From: Simon Davis
Sent: 14 January 2020 10:06
To: Ben Daines <[REDACTED]>
Cc: Chris Barker <[REDACTED]>
Subject: RE: BE/137/19/RES The Cottage, Shripney Road

Arun's emerging parking standards were used to inform the proposed development. For example, car barns were proposed in the RM application rather than garages to help the development meet the parking standards. You will also note that the emerging parking standards are referred to in the Planning Statement (paras 4.5.1 and 6.9.2). However, I have just noted that EVCPs have not been indicated on the site plan. Can this be dealt with via condition or would you rather an amended site plan was submitted showing which parking spaces have EVCPs.

Drawing Title
Detailed Site Plan

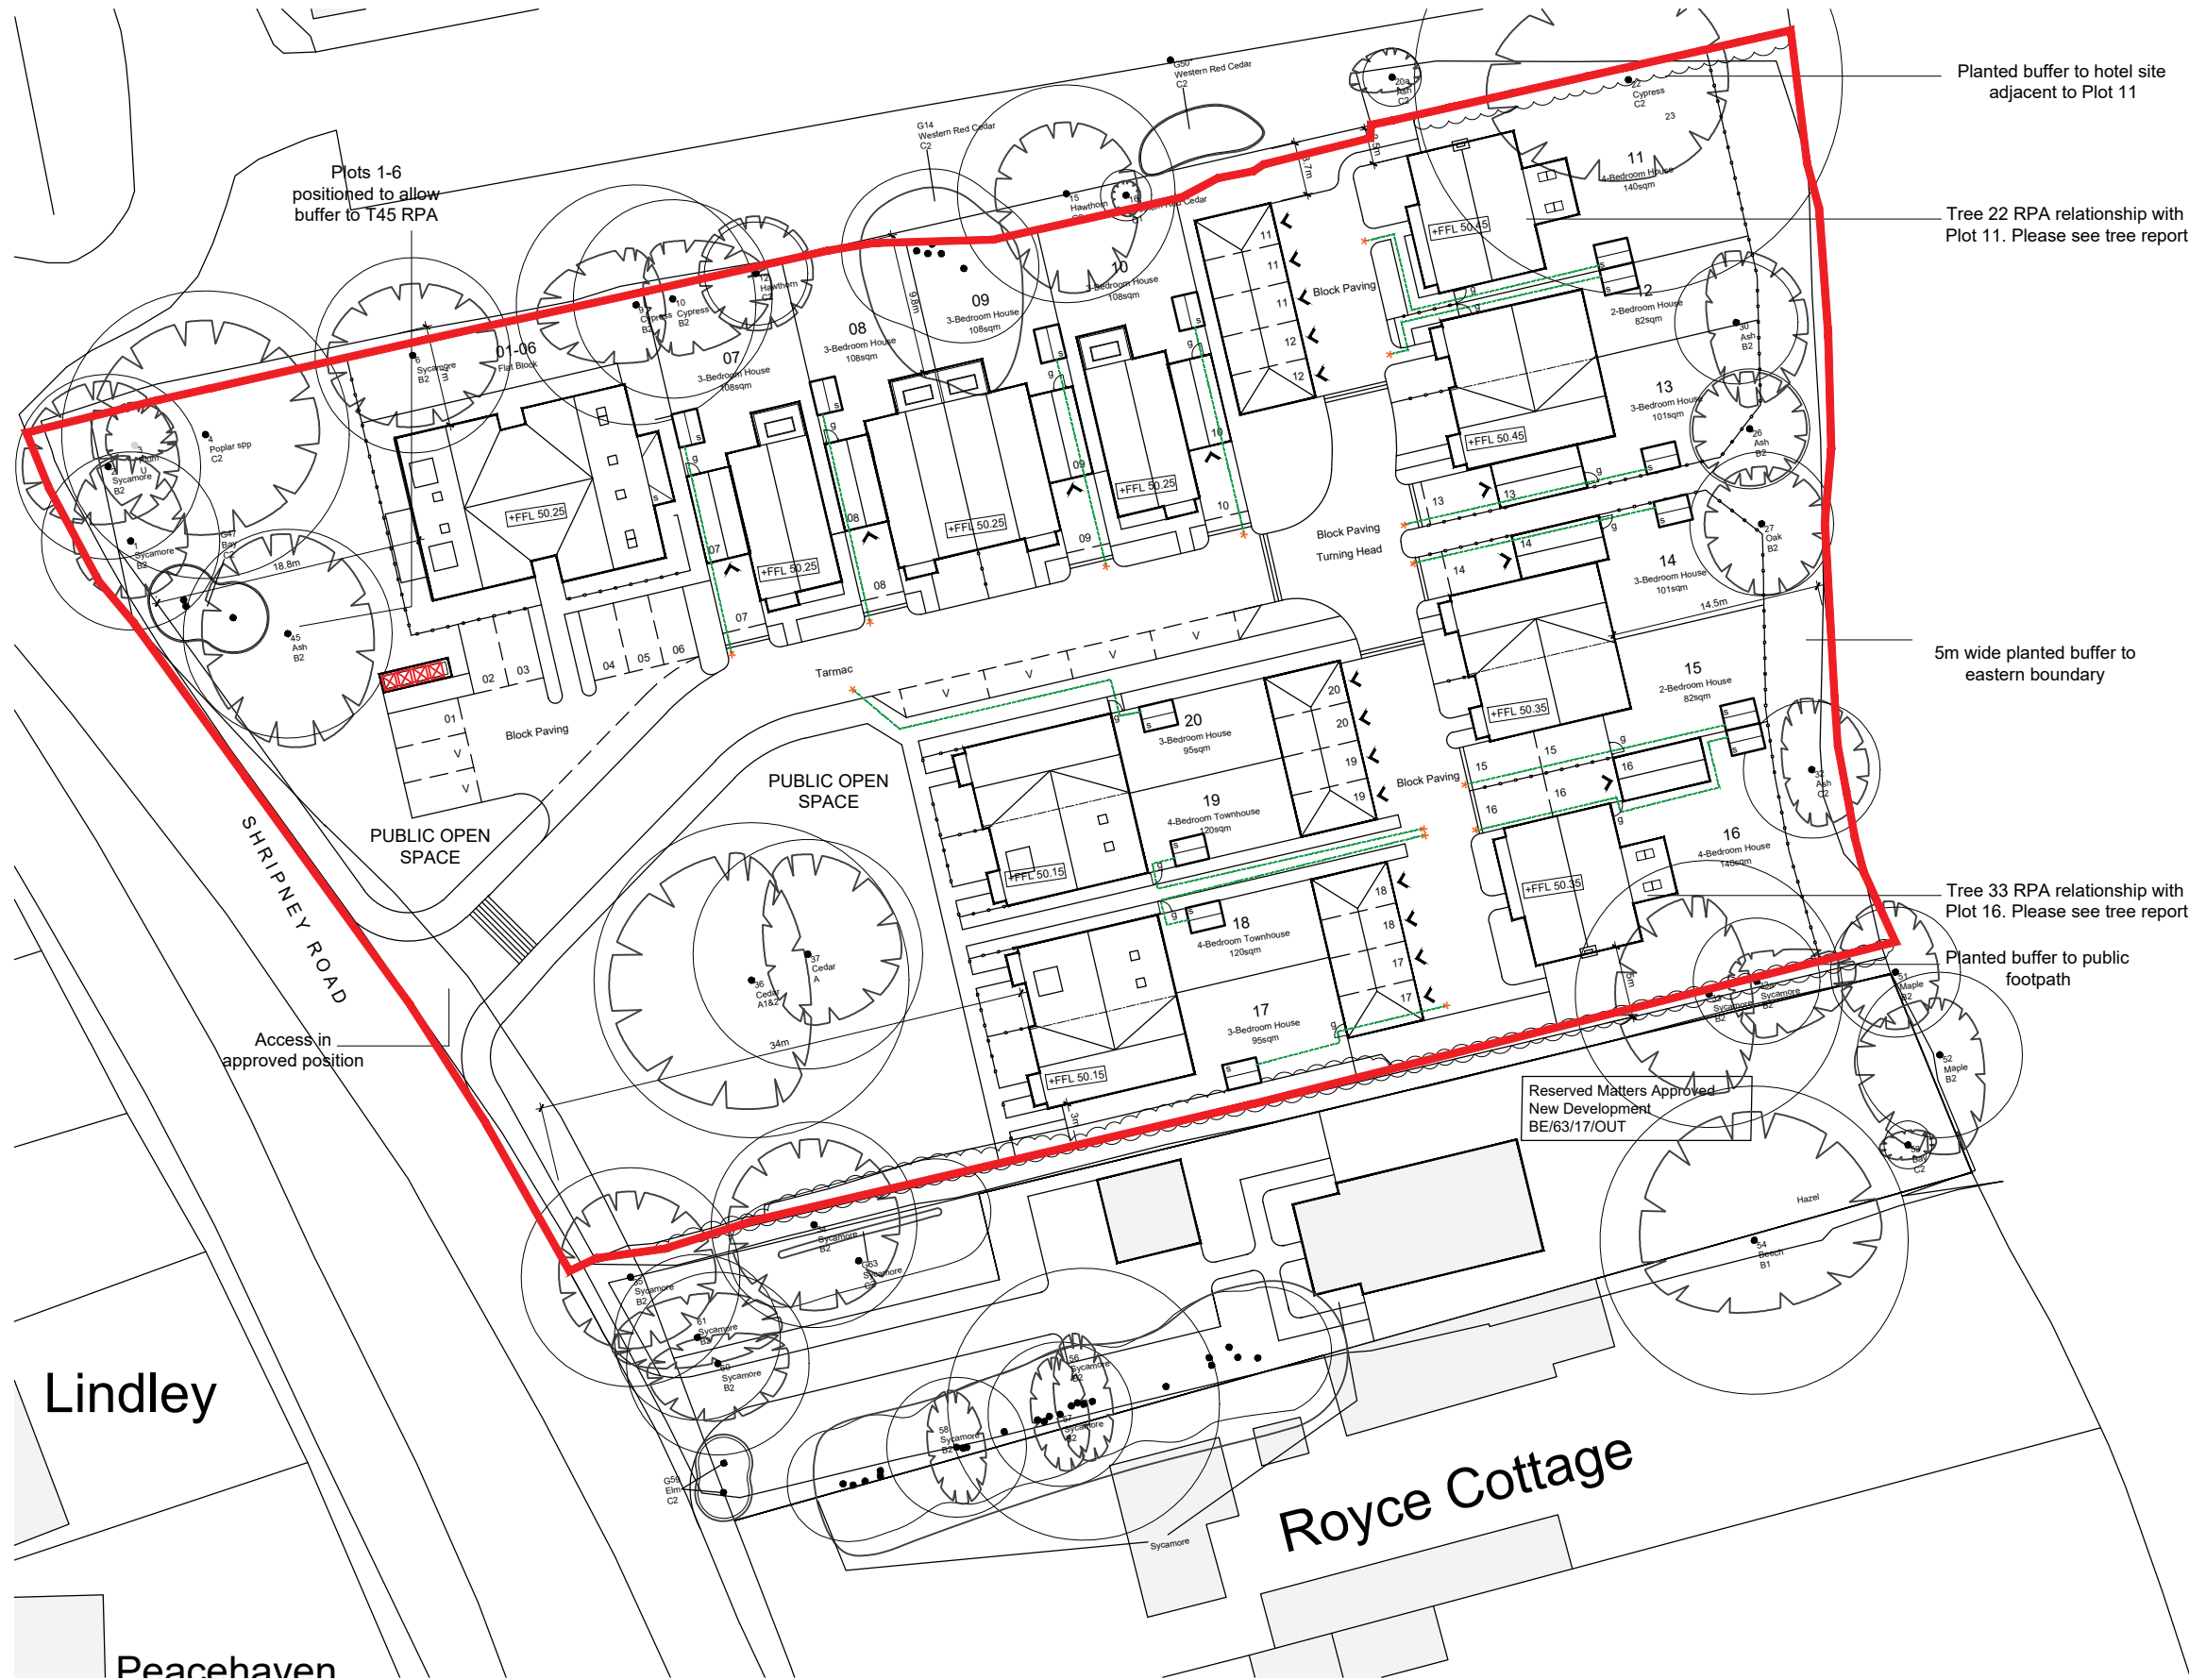
Whilst it is not unusual for EVCP's to be considered by condition, given the early stage of the application, I would suggest that it would make sense to show these on plan form now and allow for these to be considered as a key part of the site layout and save on a future condition.
